**Re: LHM Jeep Dodge
909 Virginia NE
Traffic Circulation Layout**
Engineer's/Architect's Stamp dated 3-31-16 (K19-D023)

RE: LHM Jeep Dodge Albuquerque
TCL City Review Comments
February 3, 2016

The Site Plan has been changed. The proposed access on the southerly end will not be installed. The existing access to the existing smaller lot to the north will be used. There will be no additional accesses installed along Virginia St, but the two existing accesses to the existing office building will be closed.

06 Jan, 2016  
SHEET NO.  
**C1.1**

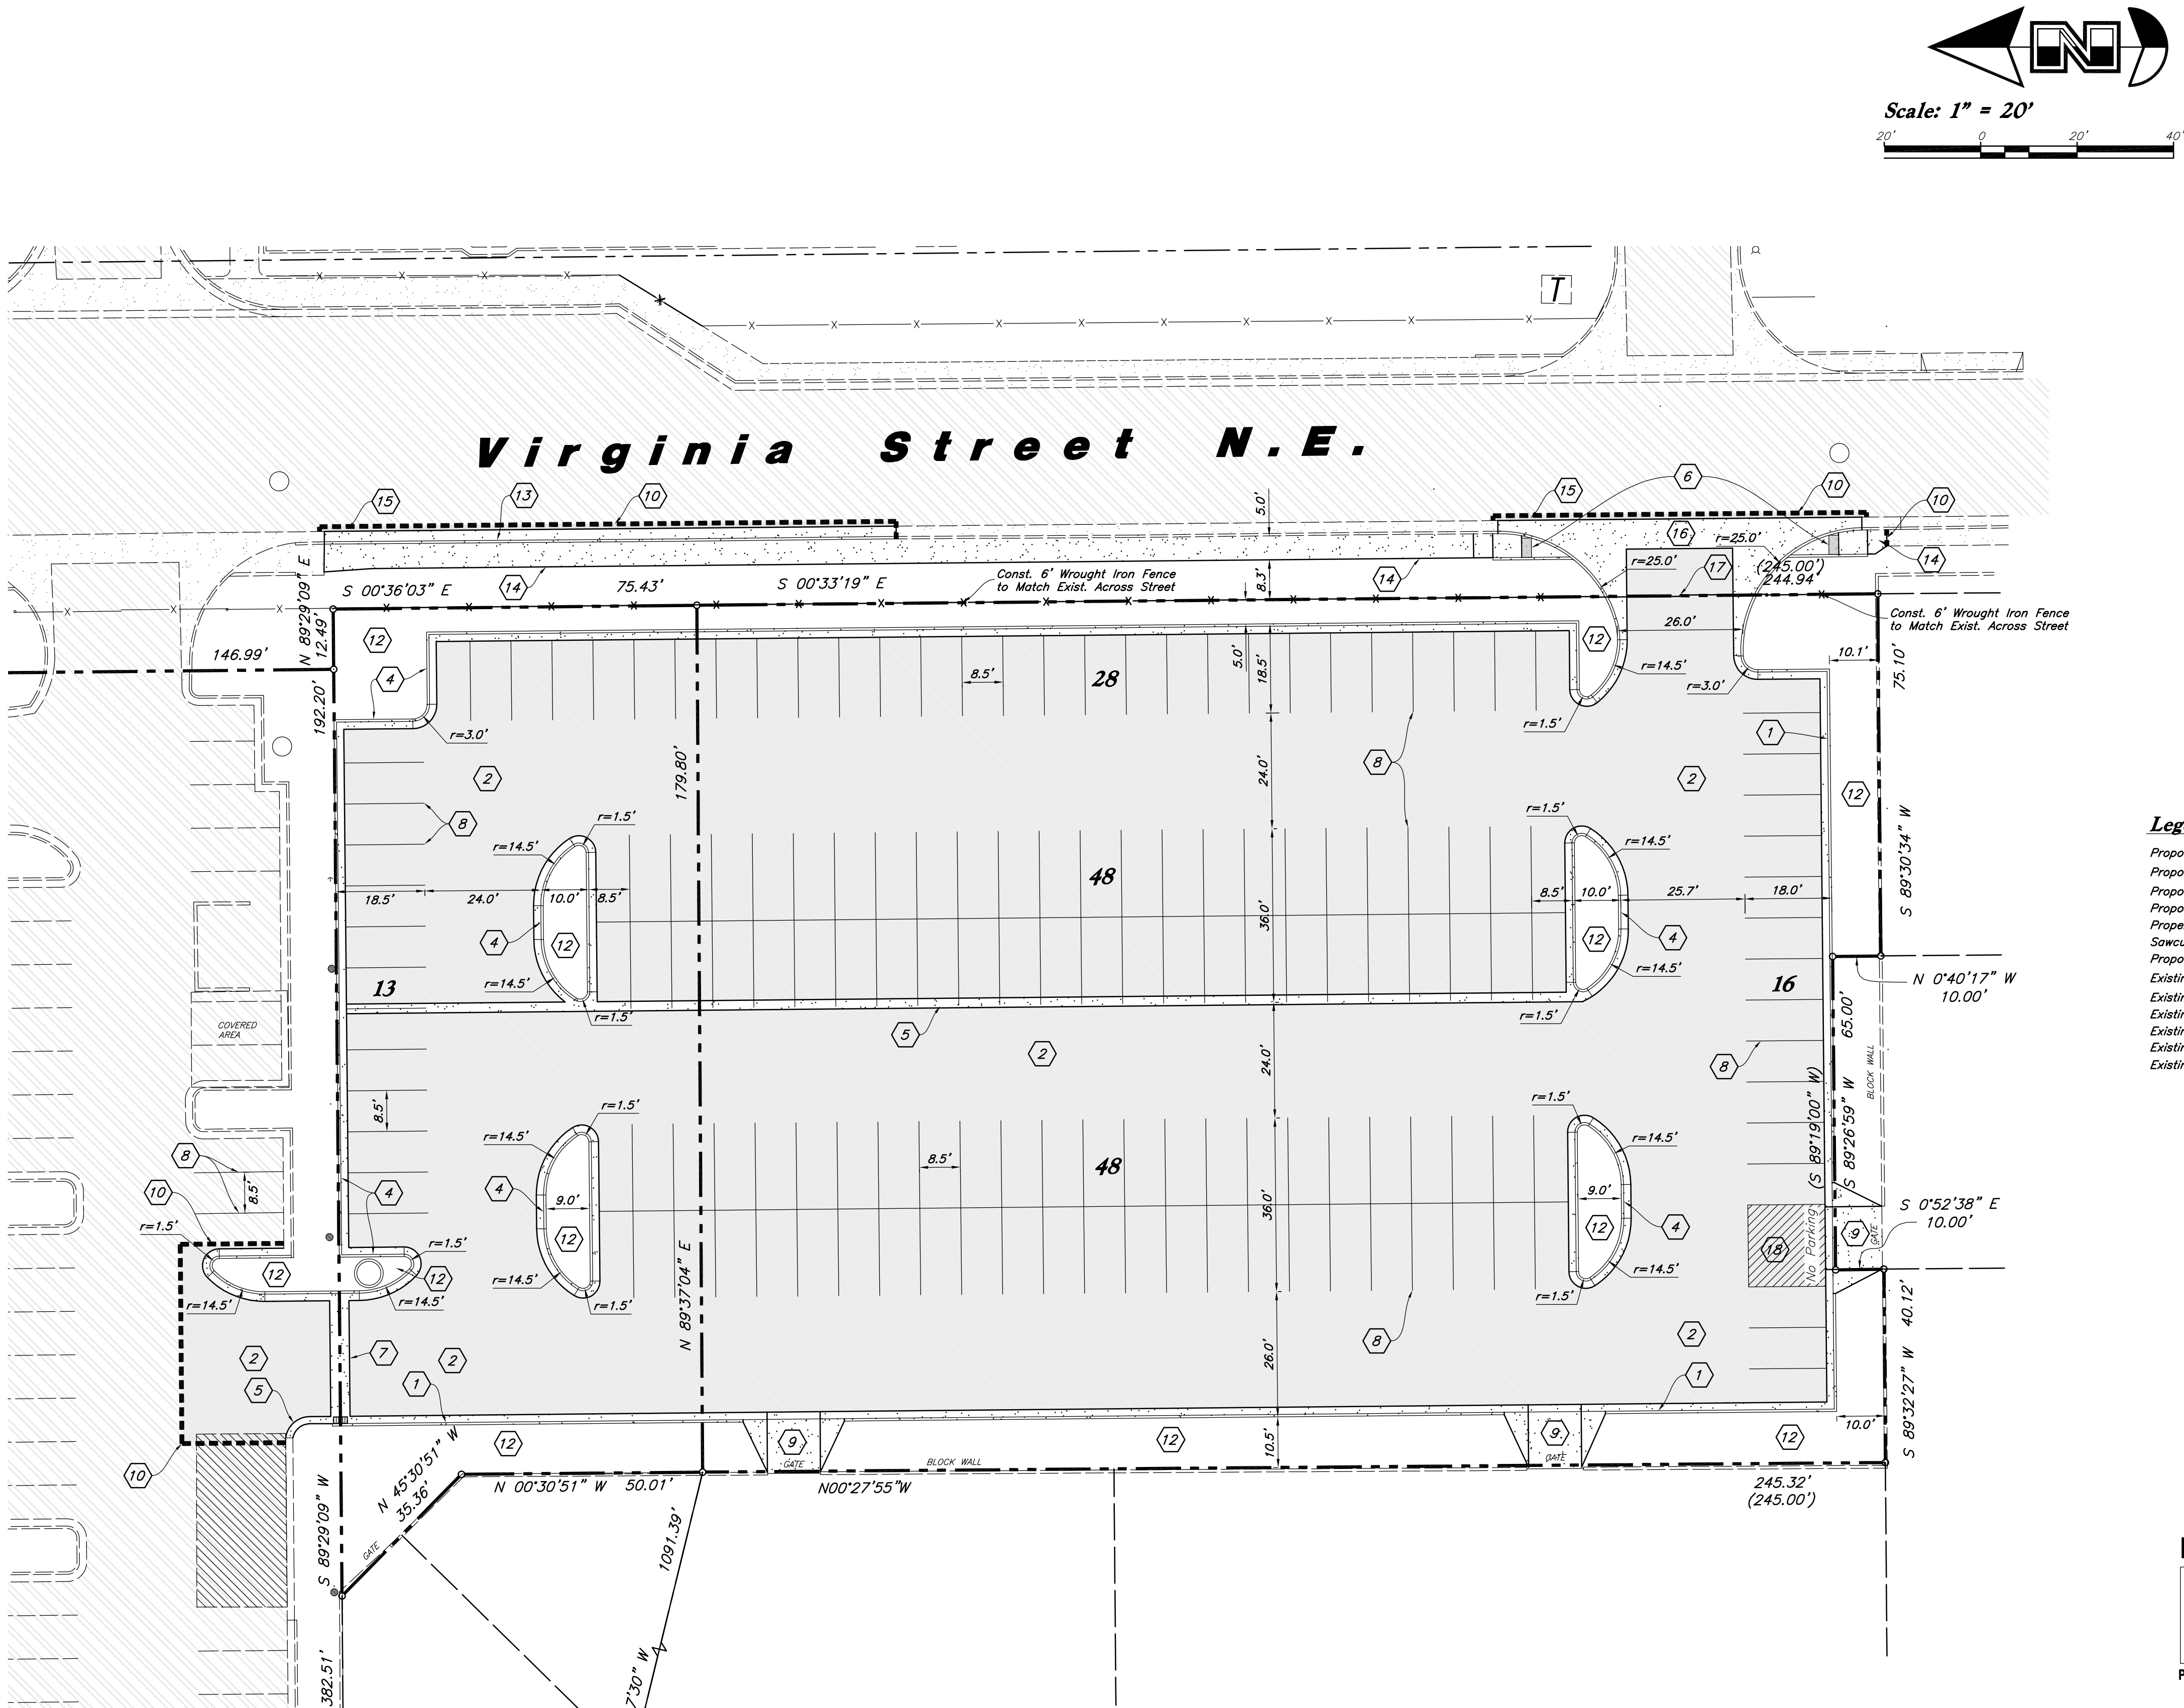
Comment 1: List the number of parking stalls required by the zoning code as well as the proposed number of parking spaces.

Comment 3: Please identify and dimension sidewalks, curbs, drive pads, walls and anything that influences the parking and circulation on the site. Dimension the drive pad entrances to the proposed parking lot from Virginia St. and from the proposed entry at the northwest corner.

Comment 4: Identify the right of way widths, medians, curb cuts, and street widths on Virginia St.

Comment 5: Please list the width for all parking spaces on the south side of the proposed parking lot.

Comment 6: Provide detail of ADA ramps at sidewalks and curbs cut entrances off of Virginia Ave. Truncated domes are required at curb cut ADA ramps.

Comment 7: Provide a min 6" or max 8" high concrete barrier curb or other acceptable barrier between landscaping and parking areas and/or drive isles. Please call this detail.

Comment 8: Please provide a sight distance exhibit (see the Development Process Manual, Chapter 23, Section 3, Part D.5 Intersection Sight Distance). Please call out this detail for the entrances/exits off of Virginia Ave.

Comment 9: Please add the following note to the clear sight triangle: "Landscaping and signage will not interfere with clear sight requirements. Therefore, signs, walls, trees, and shrubbery between 3 and 8 feet tall (as measured from the gutter pan) will not be acceptable in this area.

Comment 12: All Broken or cracked sidewalk must be replaced with sidewalk and curb & gutter. A Build note must be provided referring to the appropriate City Standard drawing.

Response: Information added to sheet C1.1, Site Data. The number of stall required is 0 and the number of stalls provided is 153 (for additional parking and inventory storage).

Response: Dimensions added to sheet C1.1.

Response: Dimensions added to sheet C1.1, right of way is 85' north of our site and 72.5' along our site.

Response: Dimension added to sheet C1.1, all parking stalls are 8.5' wide.

Response: The existing approach will remain to give access to the site. The existing approach has required ramps. See Sheet C1.1, Site Plan.

Response: Sheet C1.1 shows the curbs and the type. The curb details are on sheet C3.1, detail 1 and 6. A 24" Curb and Gutter is proposed for the south and west side of the paved area. And a rolled Curb and Gutter is proposed for the interior. The owner prefers Rolled Curb and Gutter because they don't scuff the tires of the new cars.
Also detail for the new curb along Virginia St. is added to plans. See Sheet C3.2, Detail 13, Albuquerque Standard Drawing 2415A.

Response: Sight distance exhibit, Clear Sight Triangle, is on sheet 3.1, detail 7. Sheet C1.1 shows the Clear Sight Triangles

Response: Note added to sheet C1.1, General Site Notes: note 4. (Clear Sight Triangle: "Landscaping and signage will not interfere with clear sight requirements. Therefore, signs, walls, trees, and shrubbery between 3 and 8 feet tall (as measured from the gutter pan) will not be acceptable in this area.)

Response: Note added to sheet C1.1, General Site Notes: note 5. (All broken or cracked sidewalk and curb & gutter must be replaced as per city standards.)
